SUBJECT: SFD2206-0033
SINGLE FAMILY DWELLING

Here are the results of all Inspections located at **90 LAMBERT LN:**

F1.0

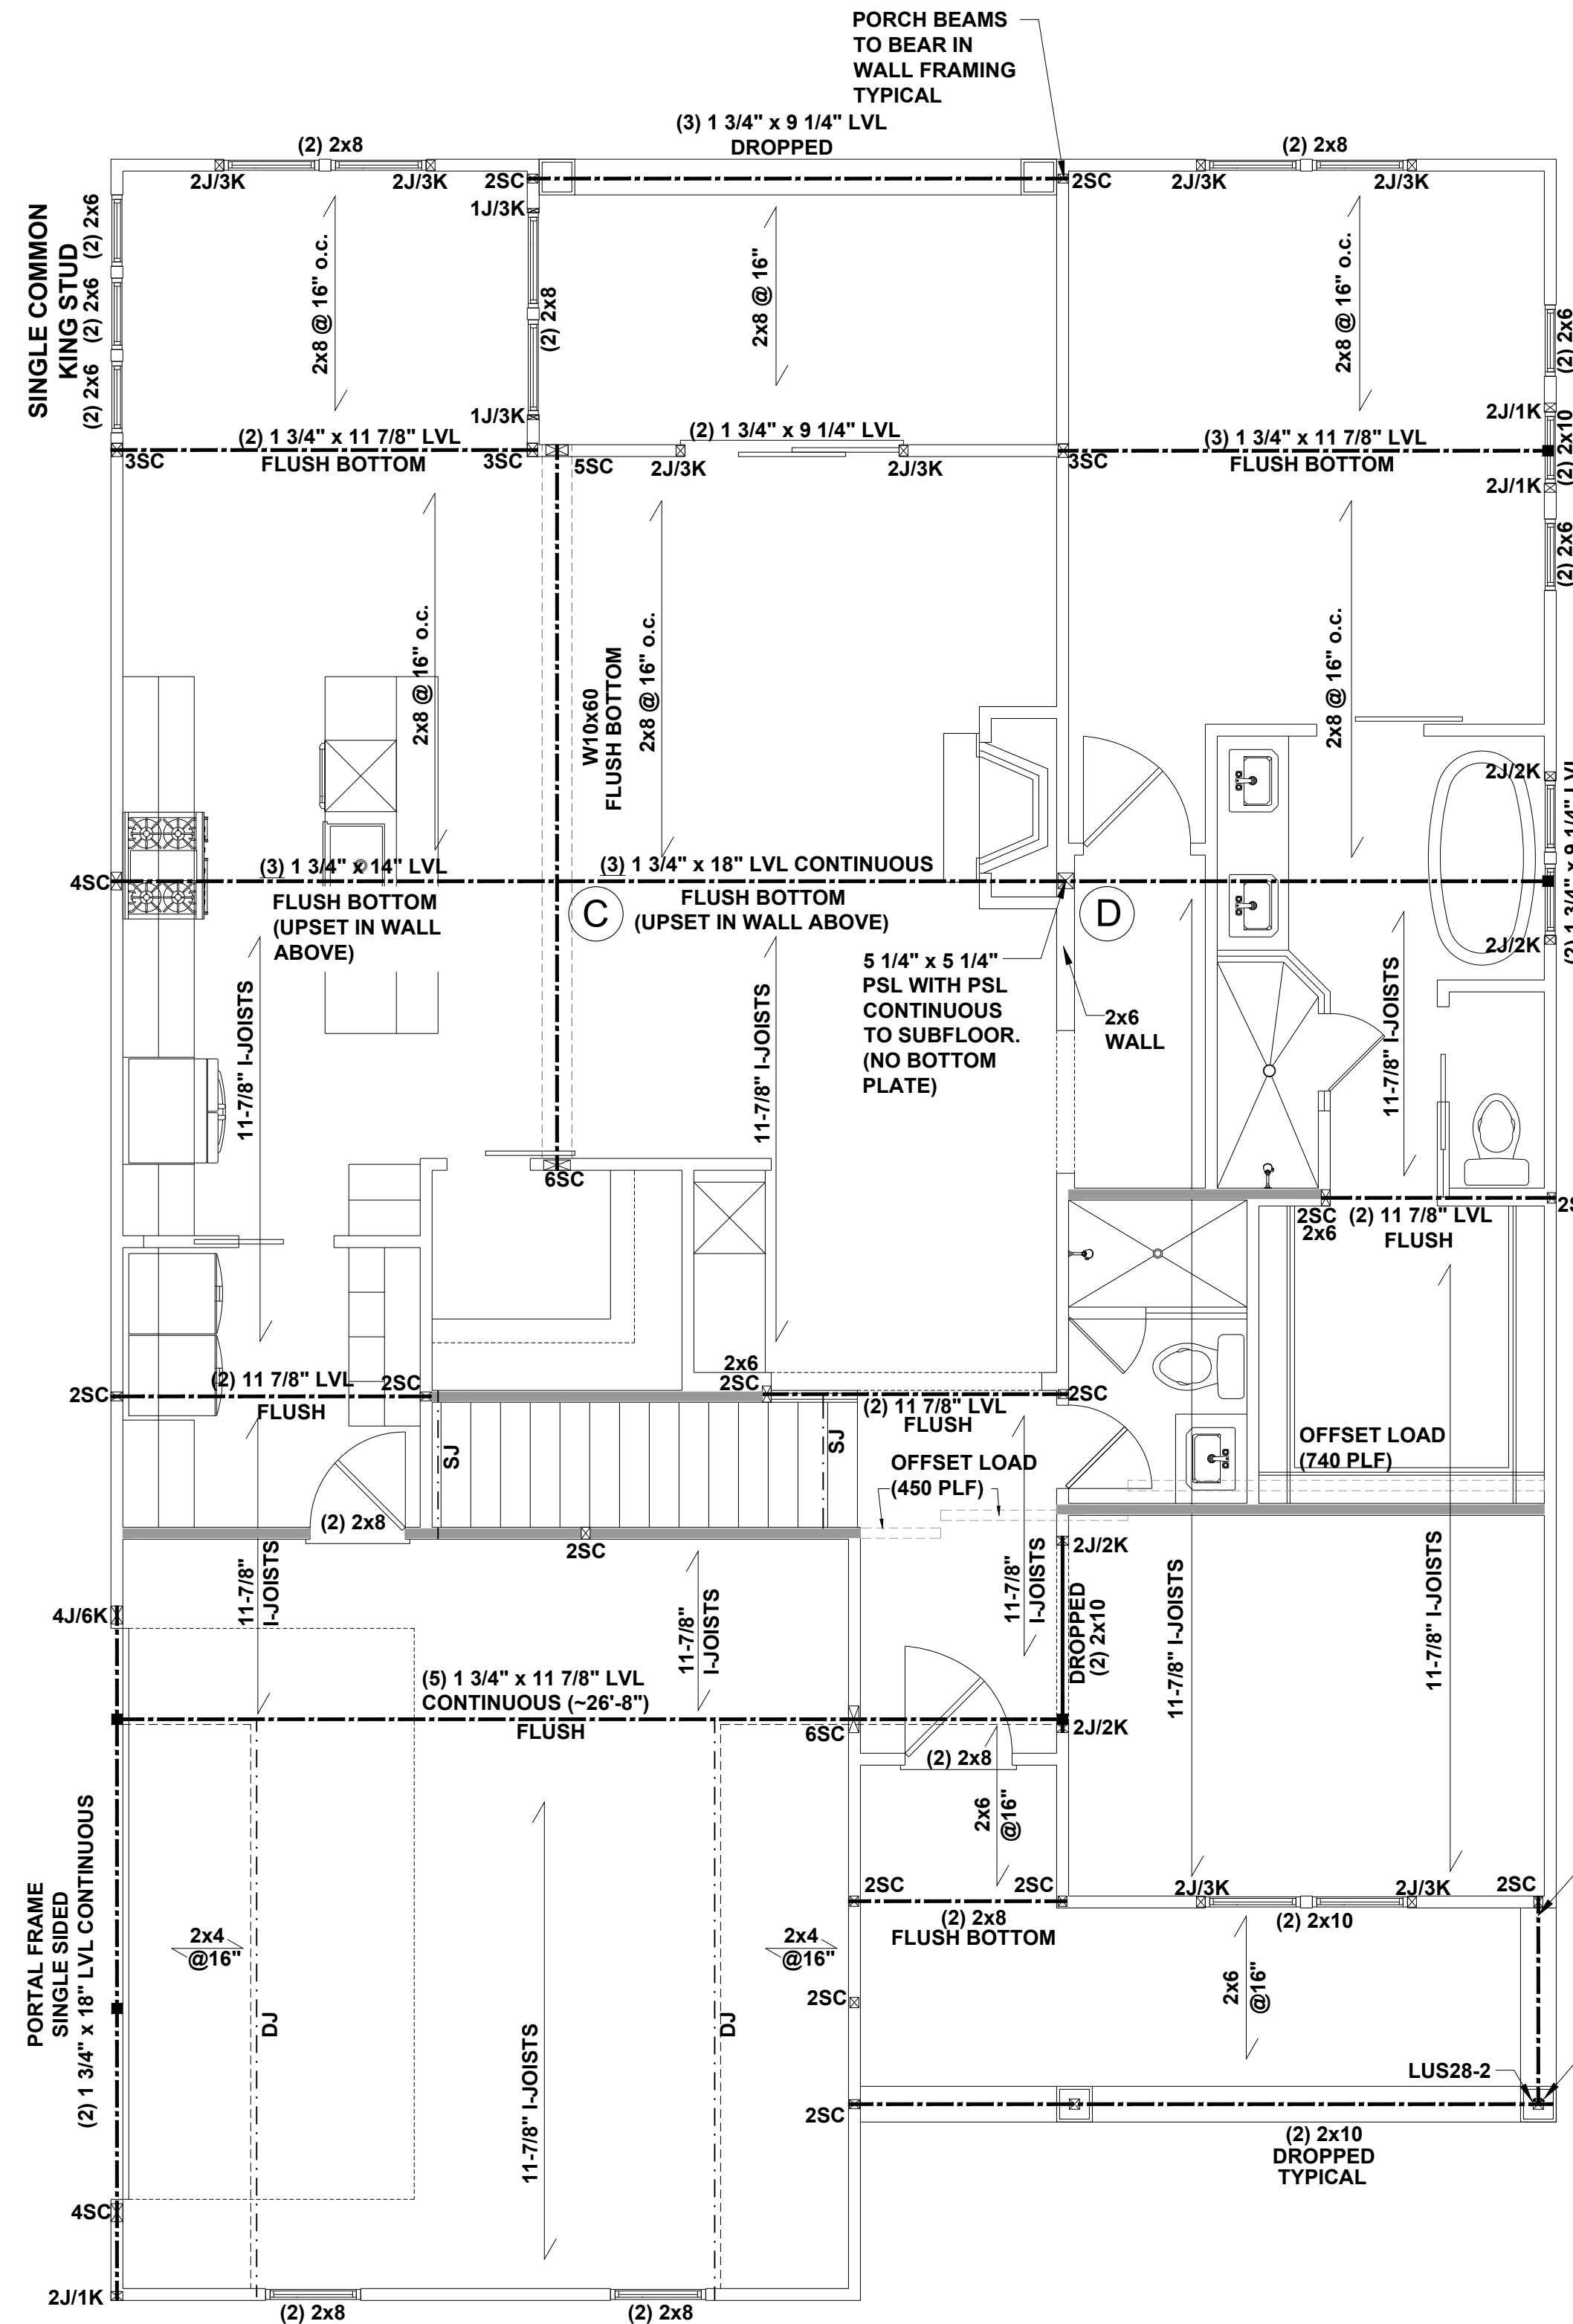
2 piers footings where dug beside to extend the foot. Need letter

Pause per engineered letter

Inspection Type: FOUNDATION
Scheduled Date/Time: 7/5/2022
Completed Date/Time: 7/5/2022
Inspector: John B Kokoszka
Result: APPROVED
Remarks: eTRAKiT Inspection Request
Notes: 6/29/2022 3:48 PM TBP Homes of Raleigh
3rd party footing letter is attached. Foundation survey also attached.
Contact Name: TBP Homes of Raleigh
Site Address: 90 LAMBERT LN
Phone: 9195018625
e-Mail: planning@trianglebuild.com

7/1/2022 1:03 PM TBP Homes of Raleigh
Pier repair letter attached.
Contact Name: TBP Homes of Raleigh
Site Address: 90 LAMBERT LN
Phone: 9195018625
e-Mail: planning@trianglebuild.com

S1.1

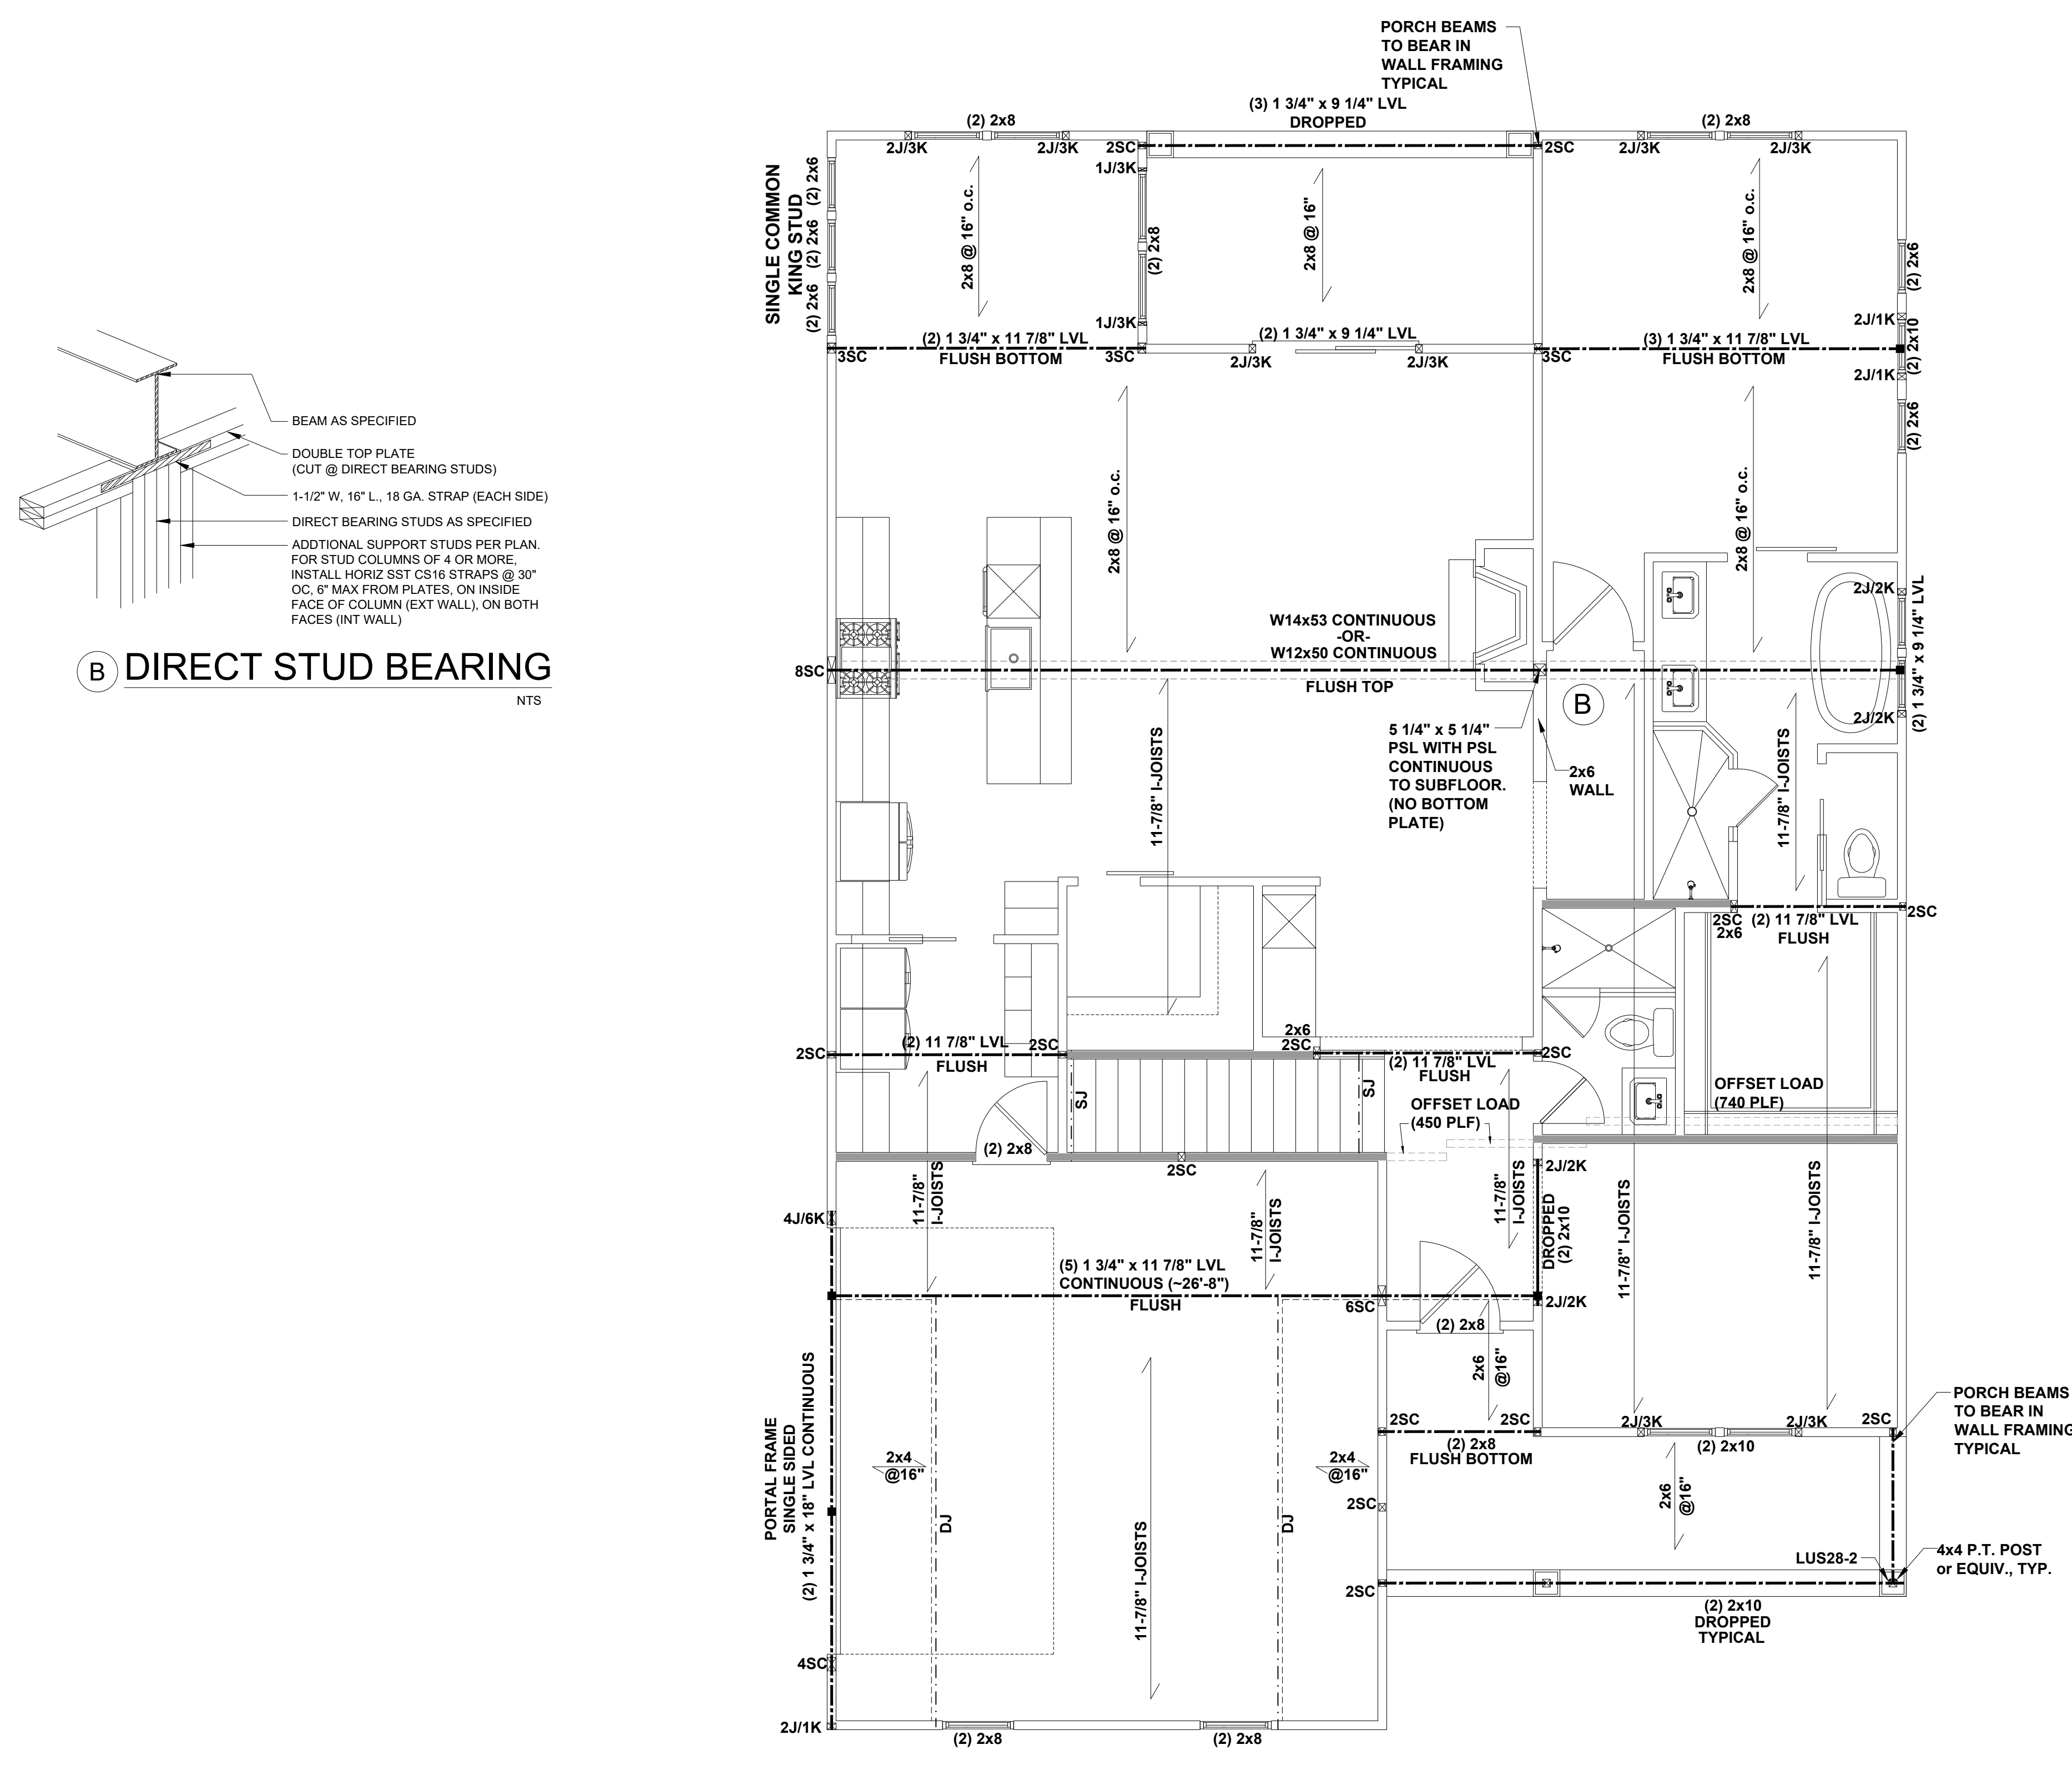
Inspection Type: 1. Plan calls for 2x6 column under lvl at master shower. 2. Head test empty. 3. Low pressure. 4. Scheduled Date/Time: No roof boots. 5. Missing L70 clips in room above garage at double 2x8. 6. Cannot bore 3 Completed Date/Time: consecutive load bearing studs at upstairs bath vanity per r602.6. 7. Cannot see if front porch Inspector: rafters have hurricane clips. 8. Seal hole through floor behind fireplace. 9. Porch post missing
Result:

Items 1,5,6,8,9 from previous not done. Item one the 2x6's were added but in wrong location. The load point is at the shower corner per plan. Ok to insulate
